COMMUNITY DEVELOPMENT DEPARTMENT
501 Delta Avenue ♦ Marysville, WA 98270 ♦ (360) 363-8000

17 November 2023

Re: SP23-003, Hidden Valley Short Plat, *Technical Review 2*

RE: Hidden Valley Short Plat, File# SP23-003
5 lot preliminary short plat/PRD on 1.24 acres
12527 51st Ave NE & Parcel # 30050300302600

**PRELIMINARY SHORT PLAT &
PLANNED RESIDENTIAL DEVELOPMENT
FOR
HIDDEN VALLEY**

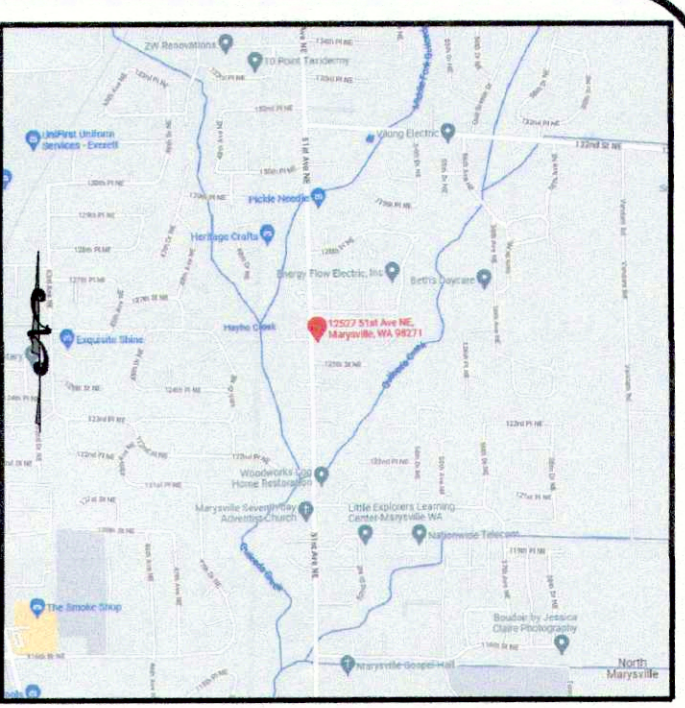
1. Amend the street configuration per memo from Kacey Simon, attached.
2. On Sheet 1 of the Civil Plans, Sheet L1, and the Preliminary Site Plan, adjust the building setback lines on Lots 1 and 3 to not encroach into the drainage easement.

4. As per item 2 on Planning's comment letter dated 27 July 2023, provide future plan submittals as clean, flattened copies, and not scans. The preliminary site plan is a scan.

5. Your response letter states that RDIs are no longer proposed. However, the preliminary site plan still shows a calculation for 1 bonus unit.
6. Amend Sheet L1 to show individual driveway, per item 4 on the comment letter dated 27 July 2023,

ROAD & GRADING

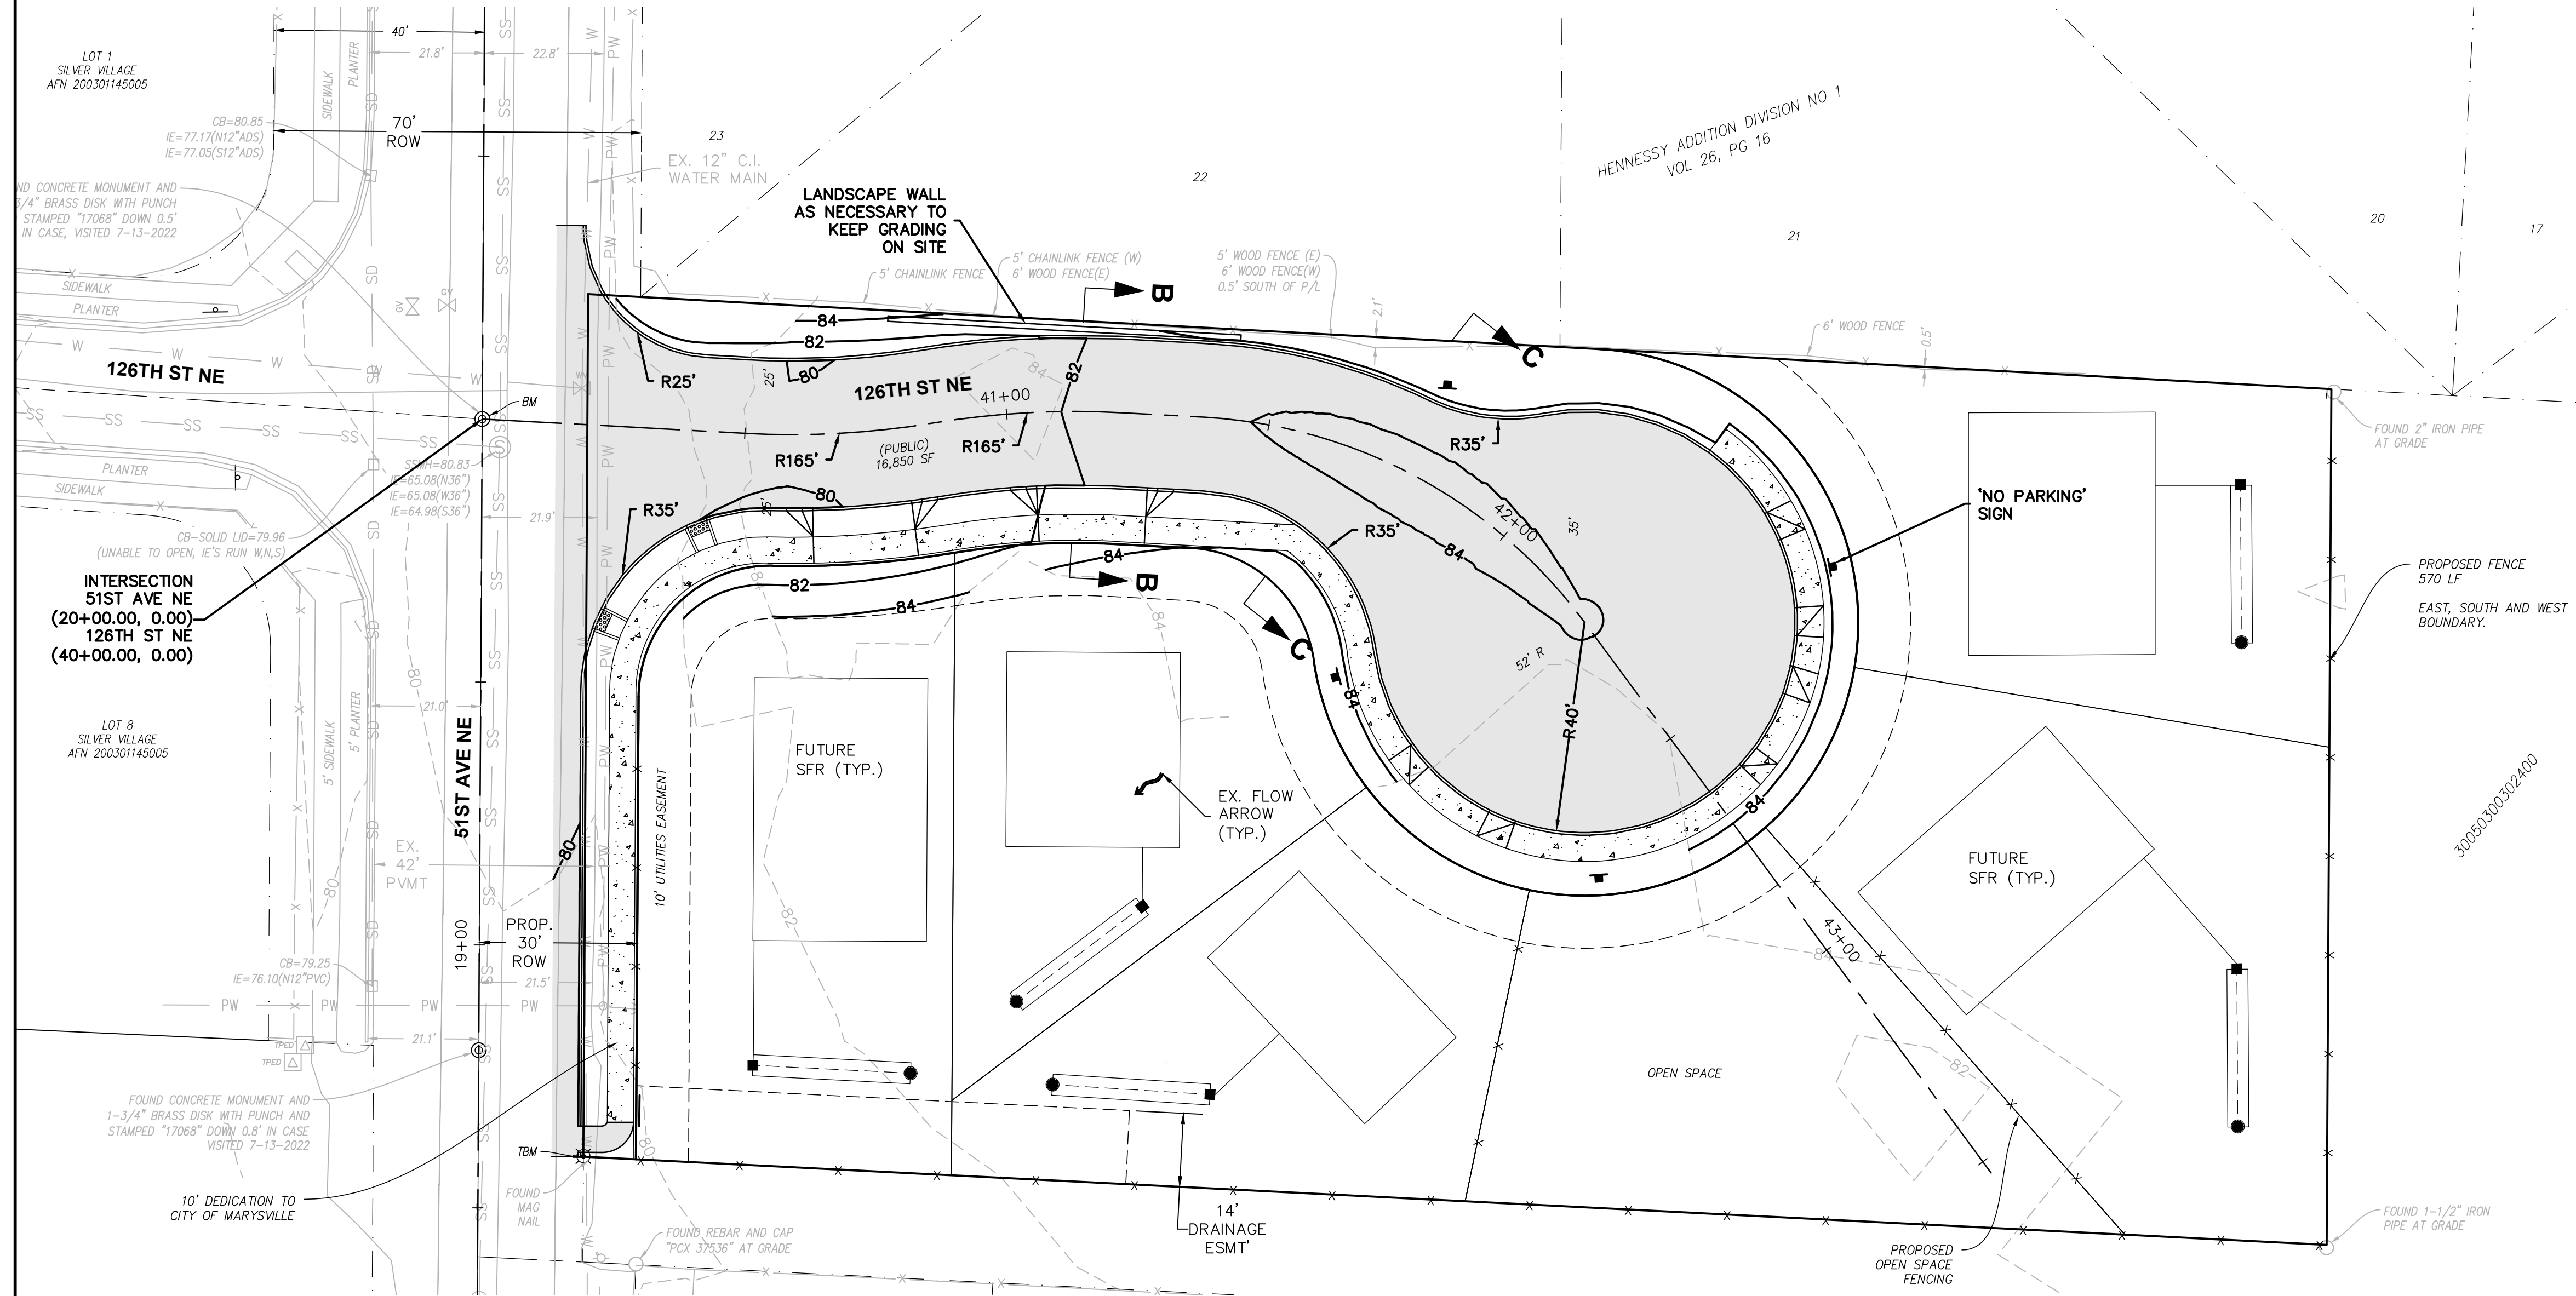
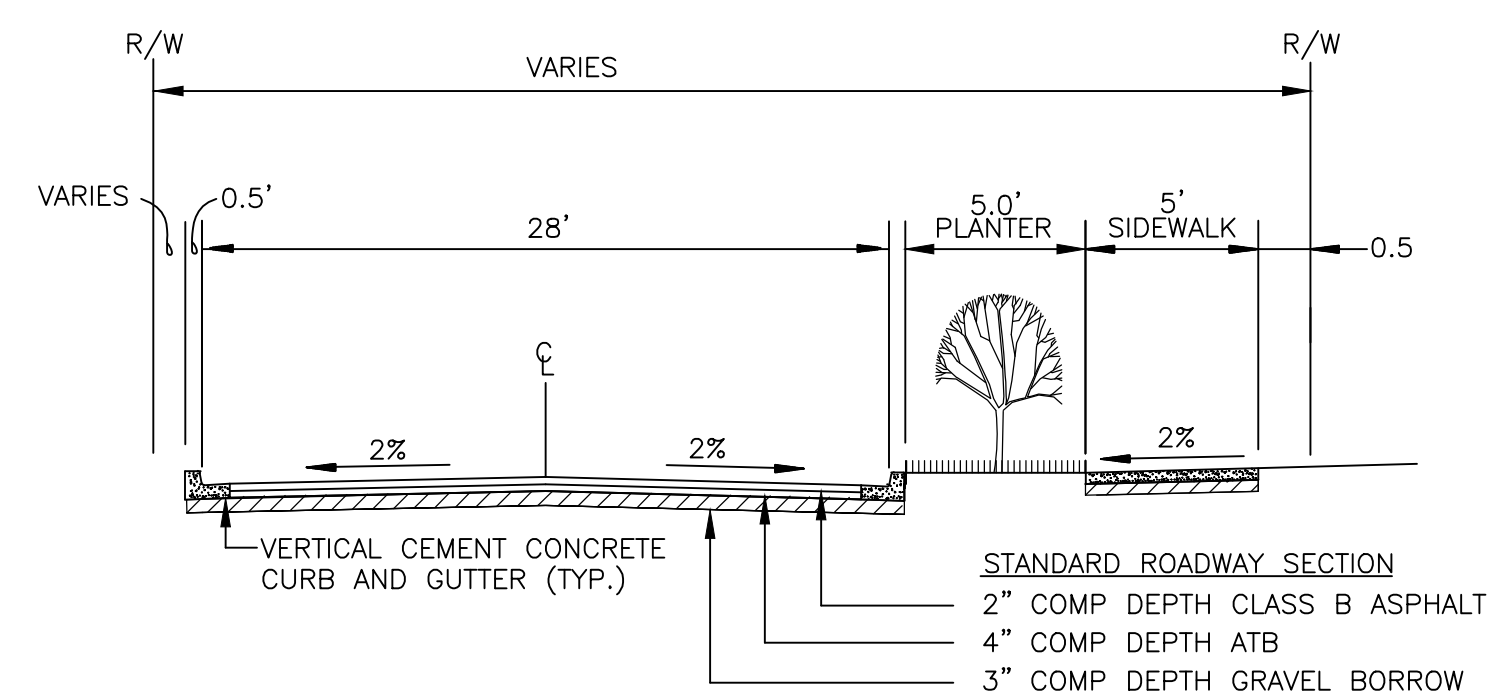
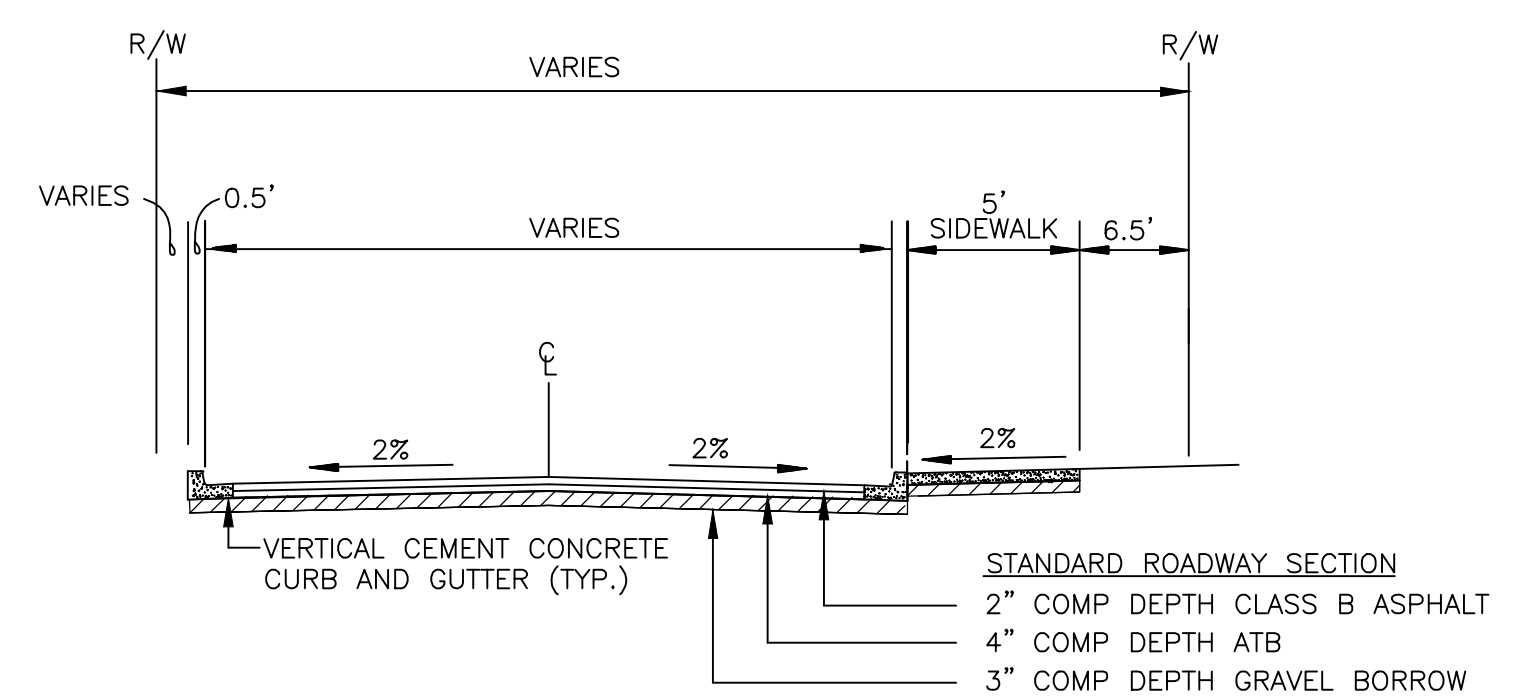
1. Homes three stories or more will require fire sprinklers and shall be shown on civil plans.
2. Turnaround must have posted signage stating: "NO PARKING - FIRE LANE" and shown on civil plans for approval.

1. **Access:**
 - a. Please provide road continuation to the east as shown on the first site plan reviewed.
2. **ROW Variance Request:**
 - a. Administrative deviation for ROW request has been disapproved provided response does not comply with MMC 12.02A.120. Please see attached findings.

**SEWER &
WATER
PLAN**

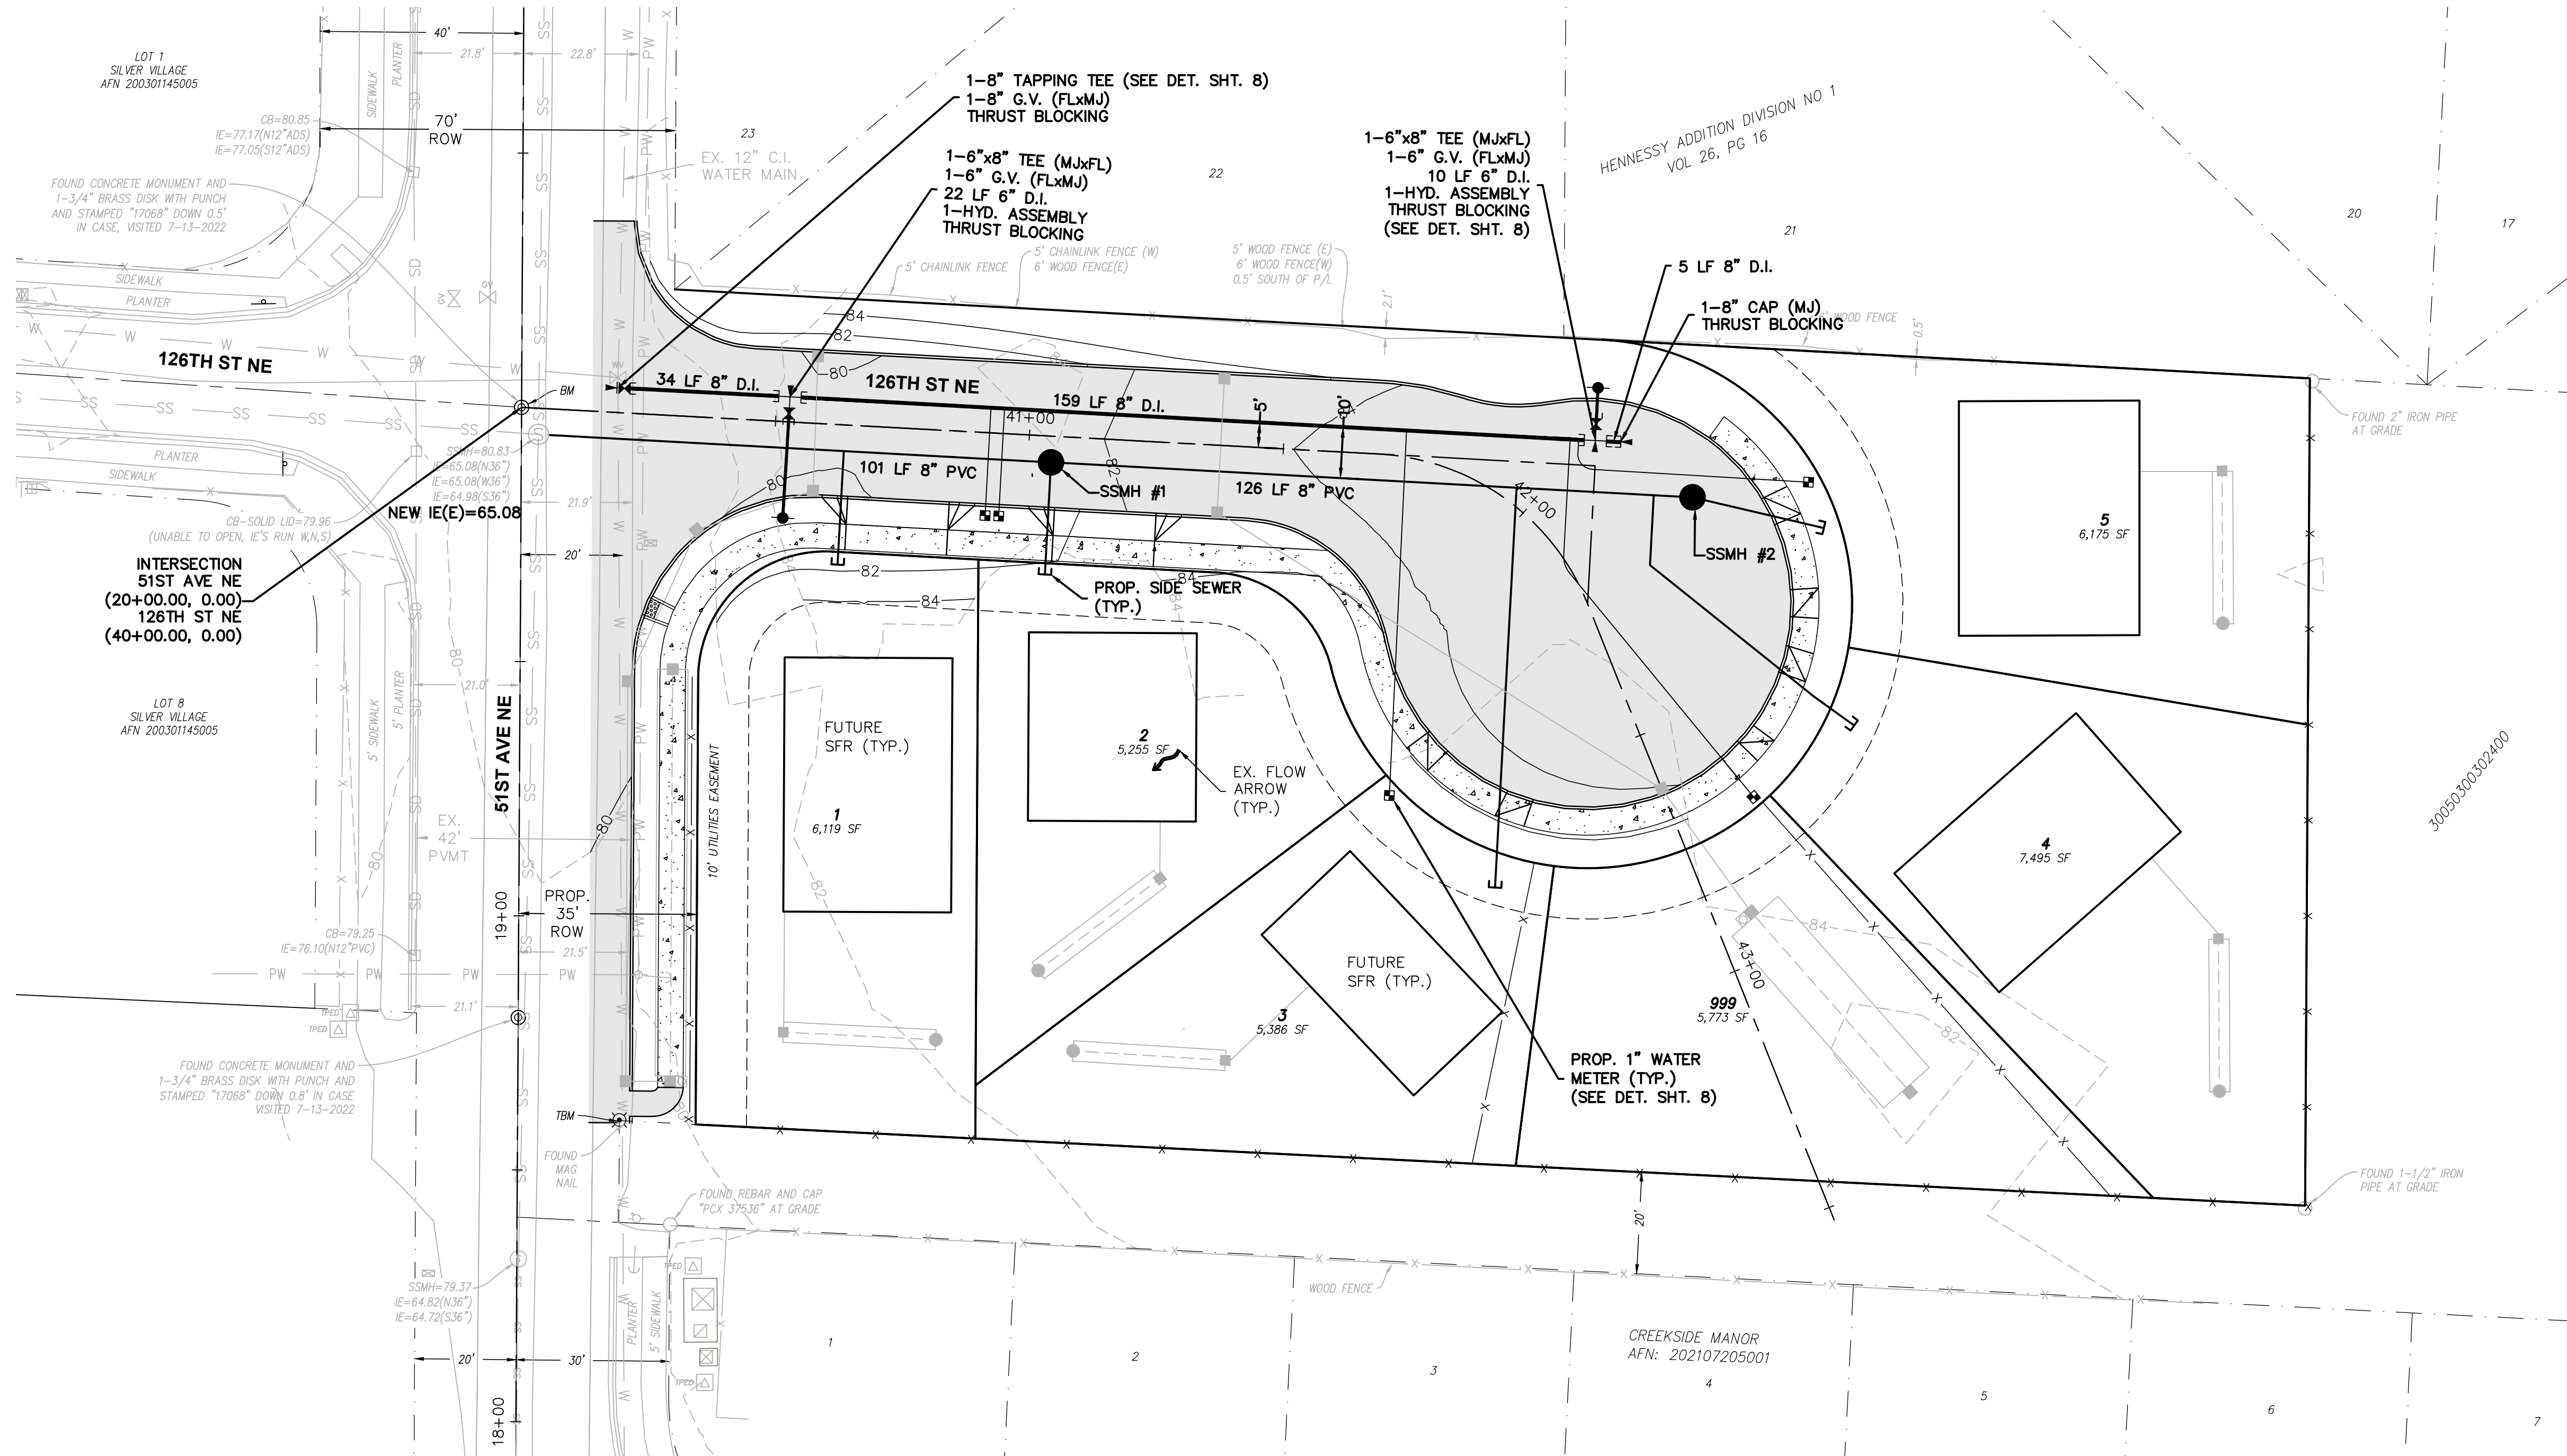
1. Suggest deleting blow off assembly and moving hydrant in its place, and tap services before hydrant.
